Cottam Solar Project

Schedule of Changes (Deadline 2)

PINS Reference: EN010133
Document Reference: EX1/C8.1.7_A
The Infrastructure Planning (Examination Procedure) Rules 2010
Rule 8(1)(k)

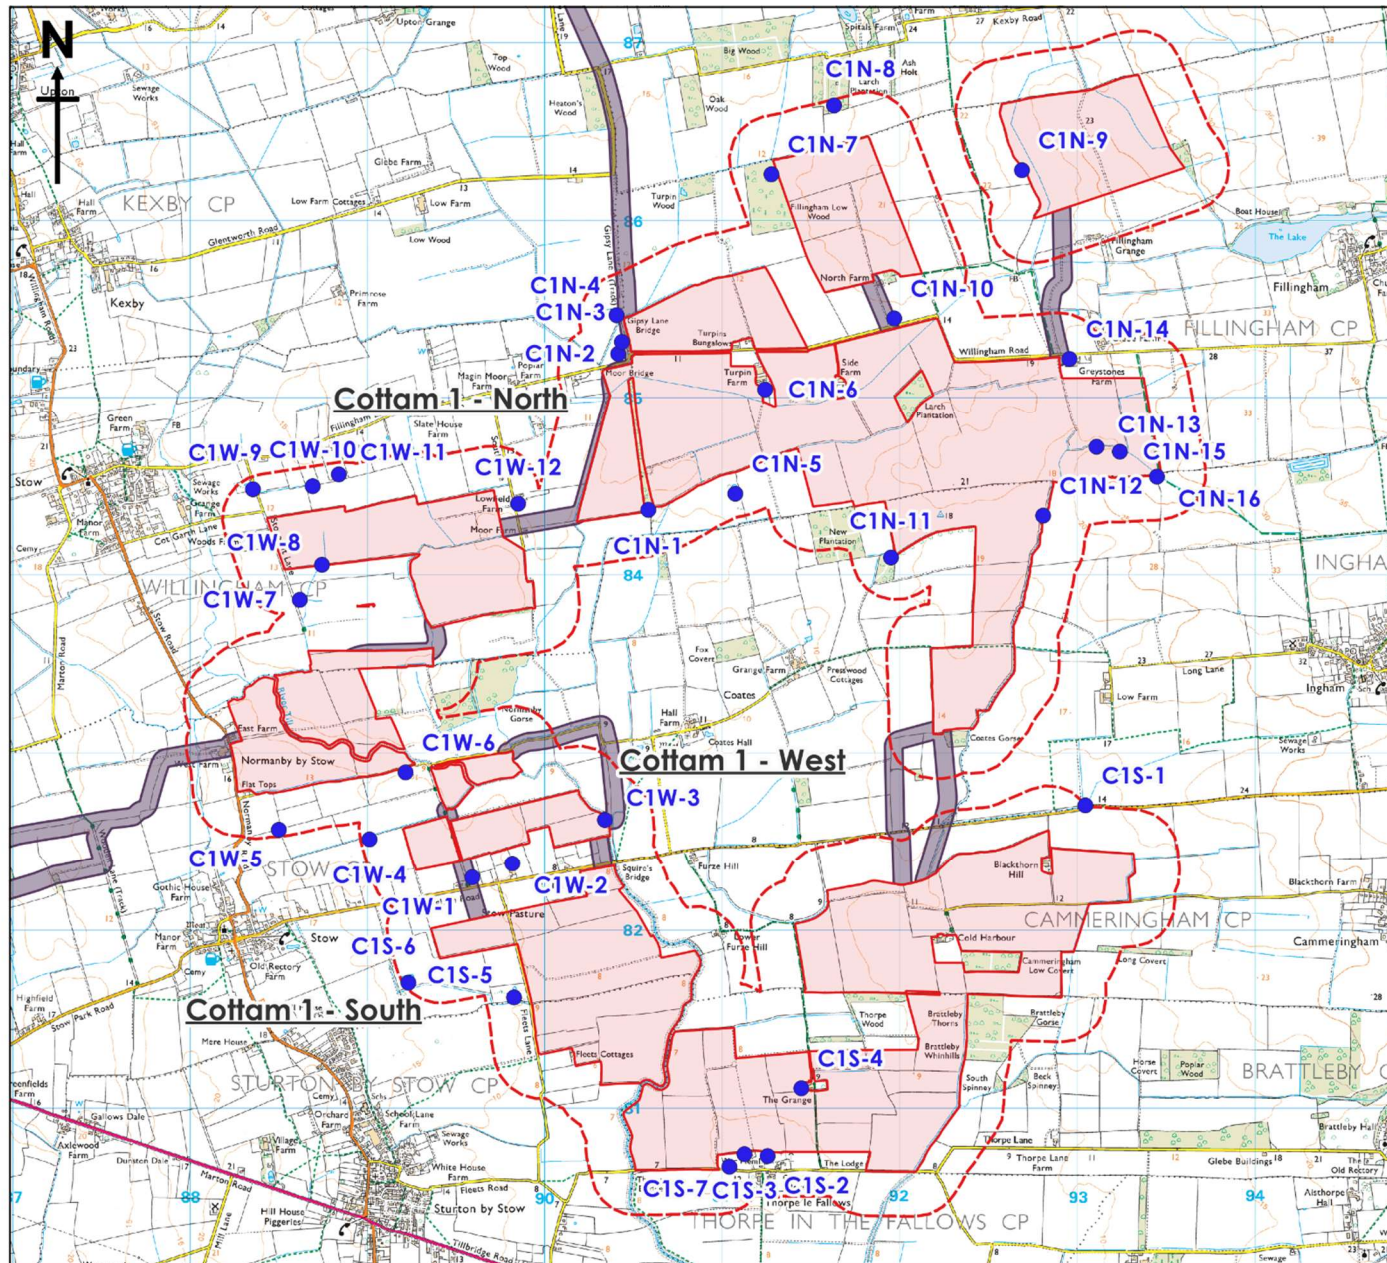
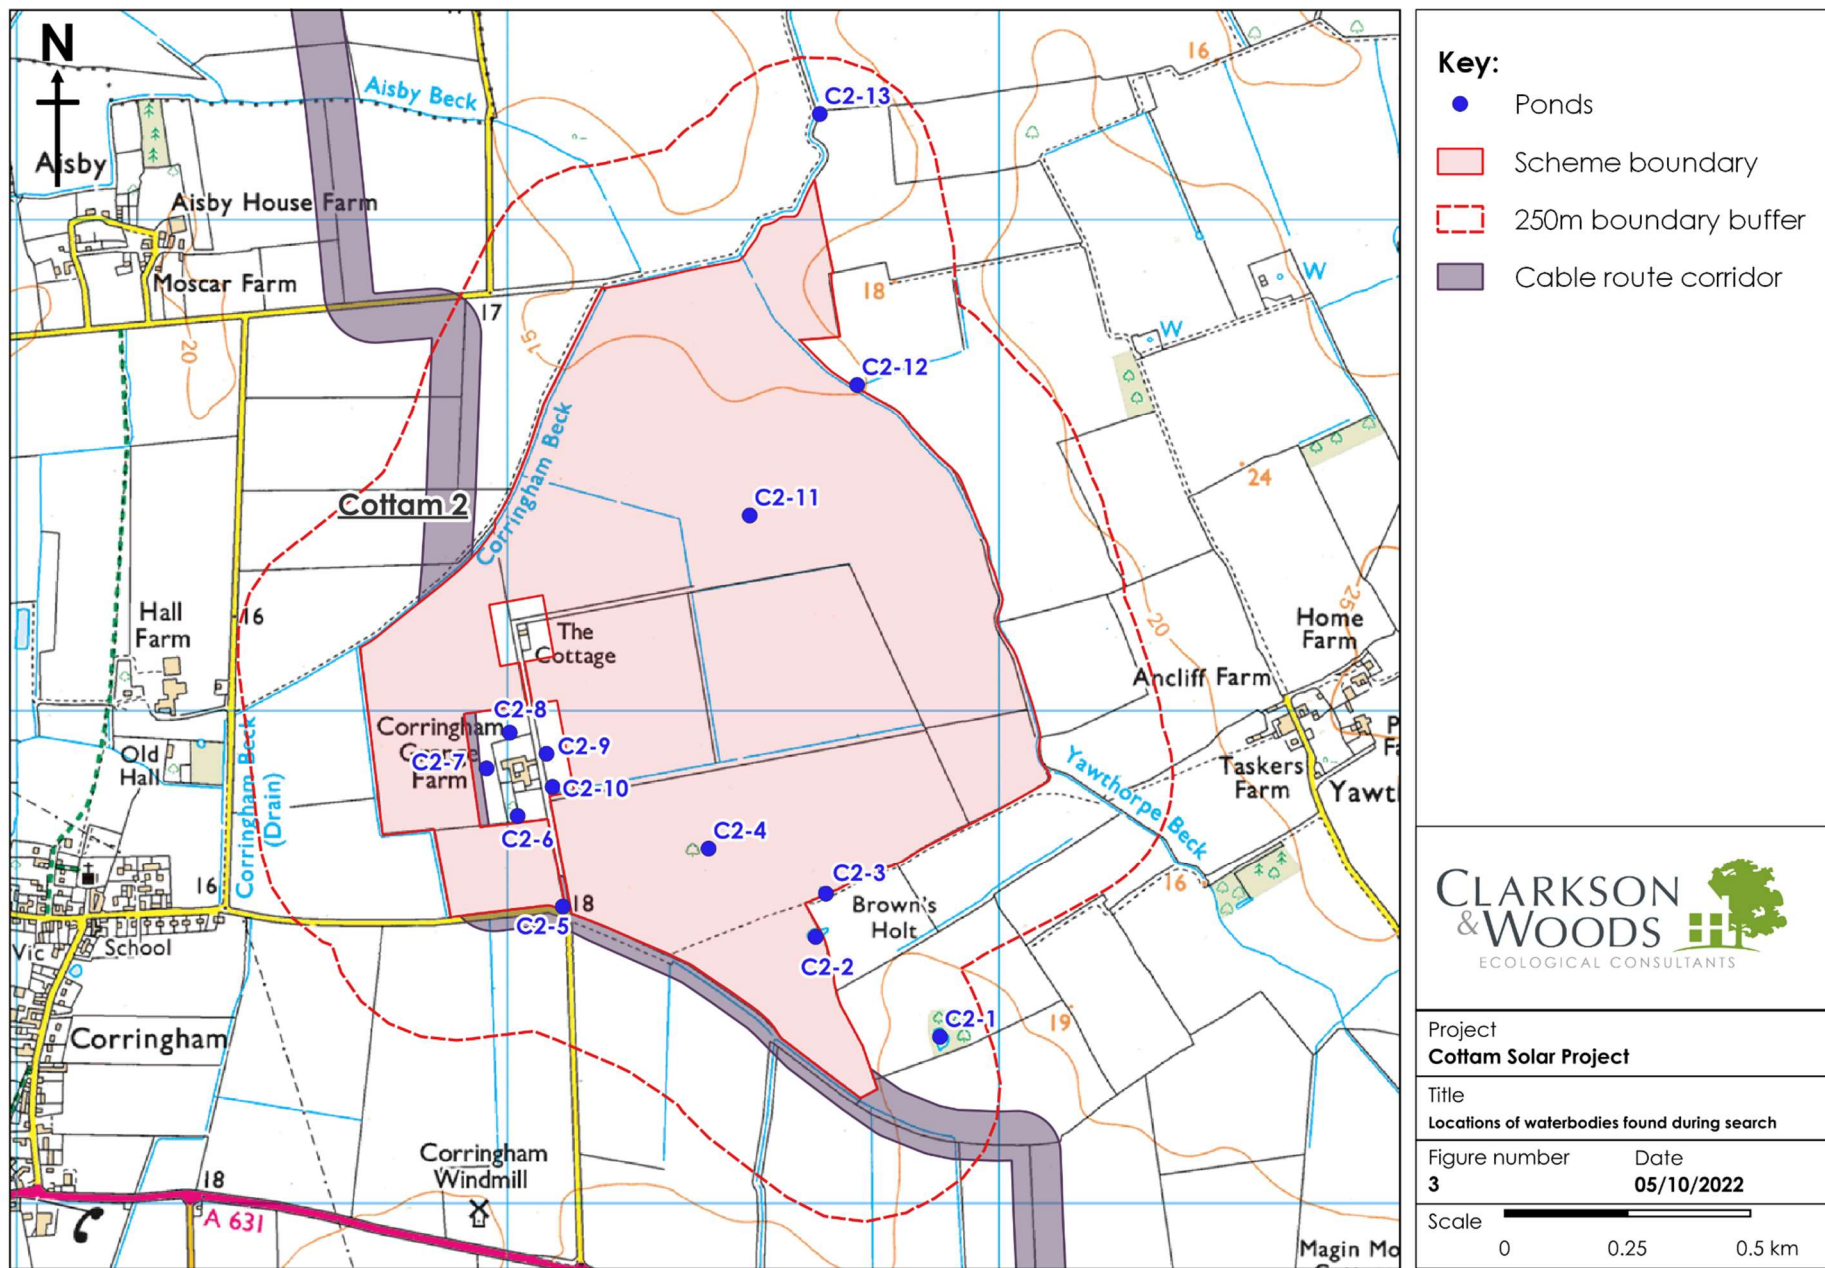
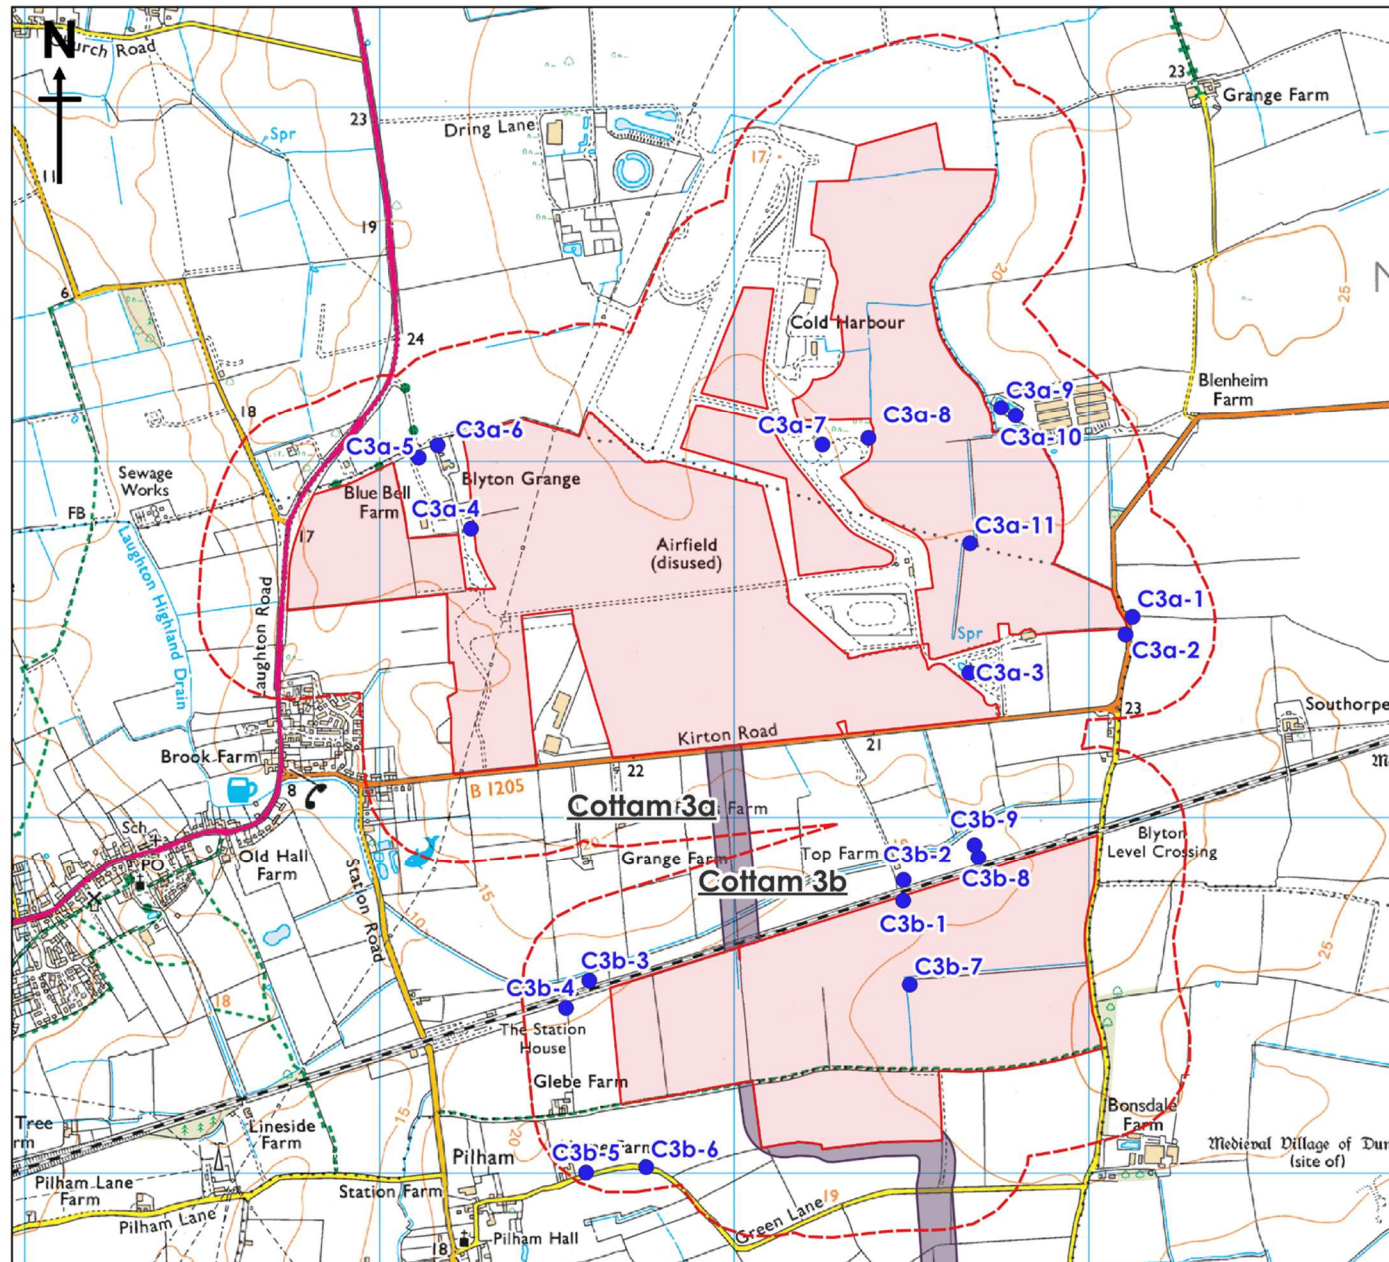
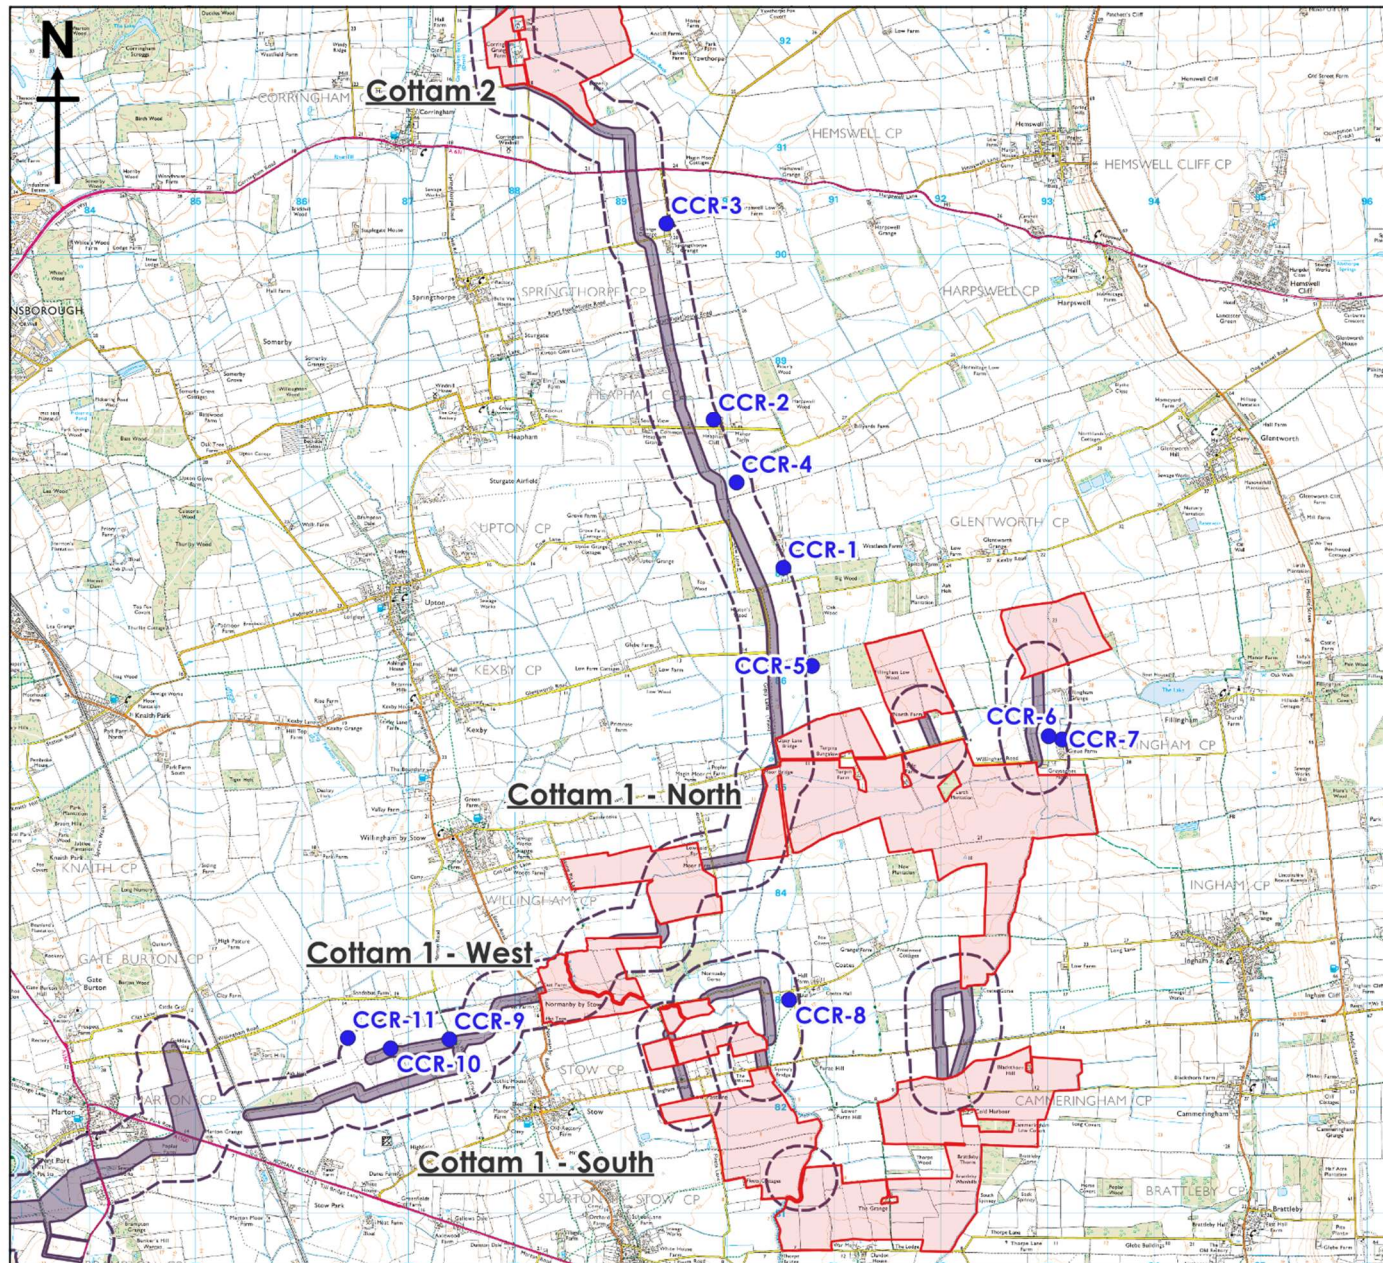
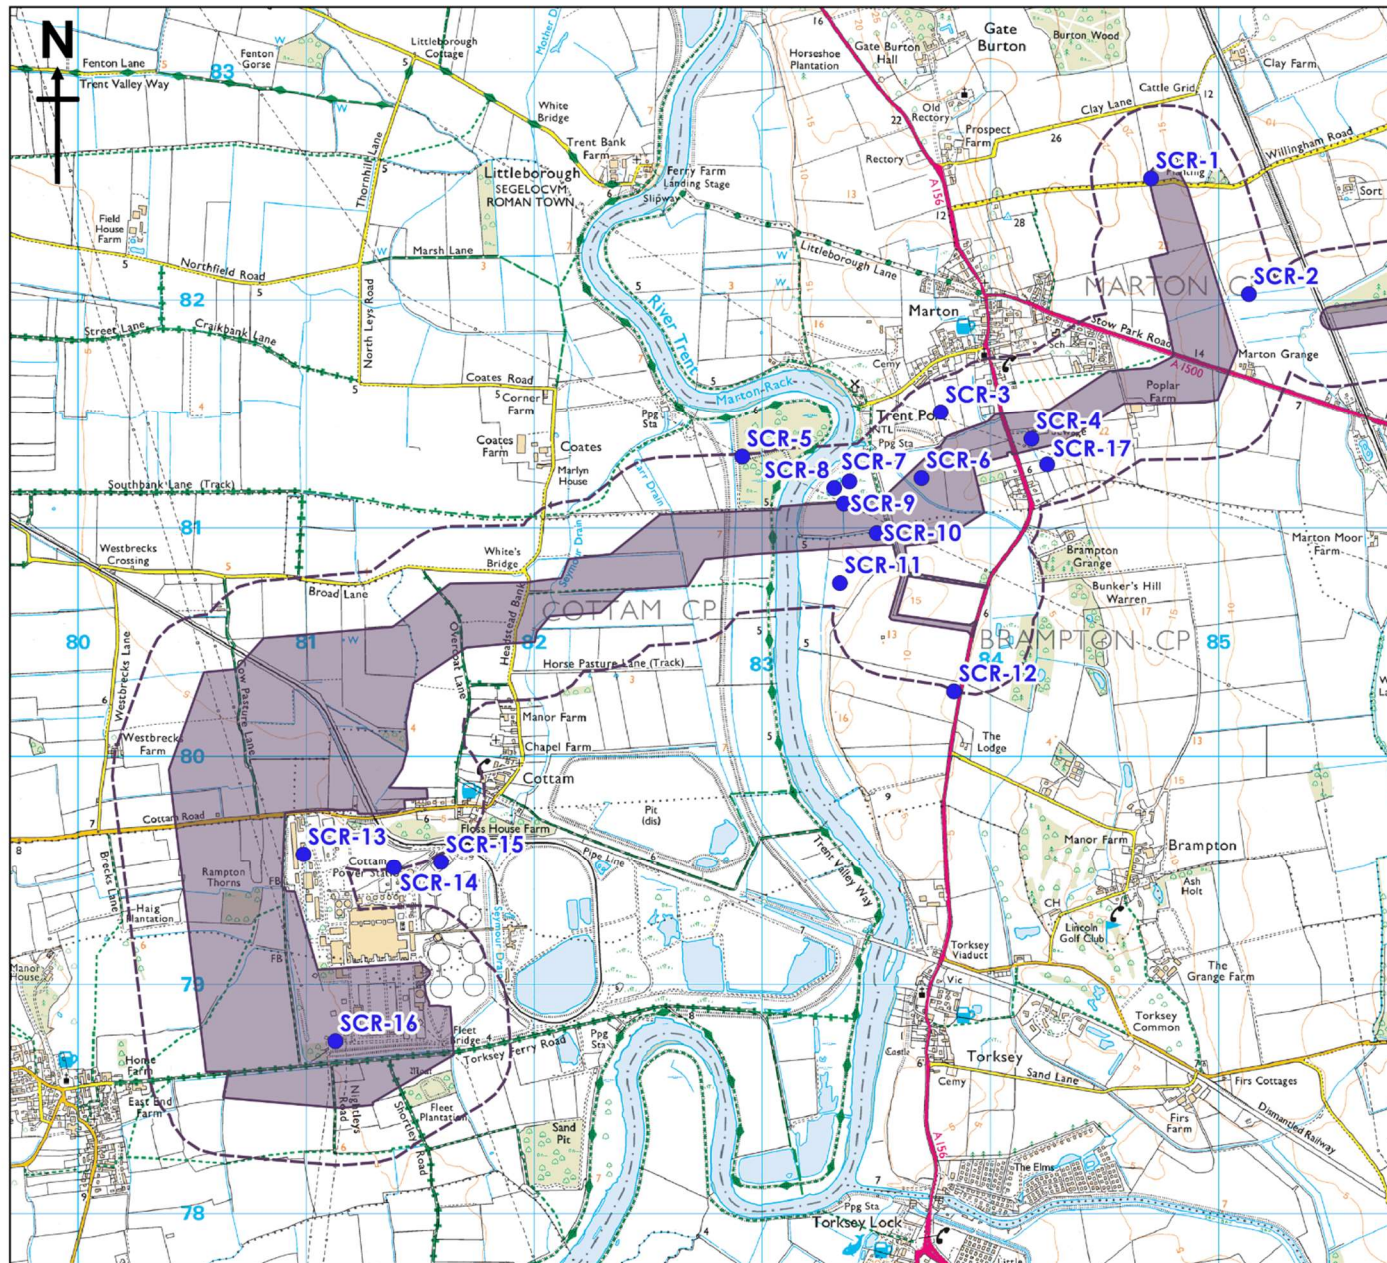
C6.3.9.7 Great Crested Newts Survey Report	[APP-084]	Revision A [EX1/ C6.3.9.7_A]	Deadline 1 17 October 2023	Paragraphs 2.2.11, 4.1.6 and Figure 11, added; Paragraph 2.2.22 deleted and Paragraphs 3.2.6, 4.1.2, 4.1.5, 4.1.7, 4.2.4 and Tables 7, 12 updated to include 2023 Great Crested Newts Survey.	To provide information on the likely presence or likely absence of Great Crested Newts for 6 additional ponds along the cable corridors where access had not been previously arranged and of a further three ponds which were previously found to be dry.
C6.3.14.2 Construction Traffic Management Plan	[APP-135]	Revision A [EX1/ C6.3.14.2_A]	Deadline 1 17 October 2023	Construction Traffic Management Plan updated to take equestrians and reinstatement of private roads into account.	ExA Request ISH1 and to address the British Horse Society's Relevant Representation [RR-023].
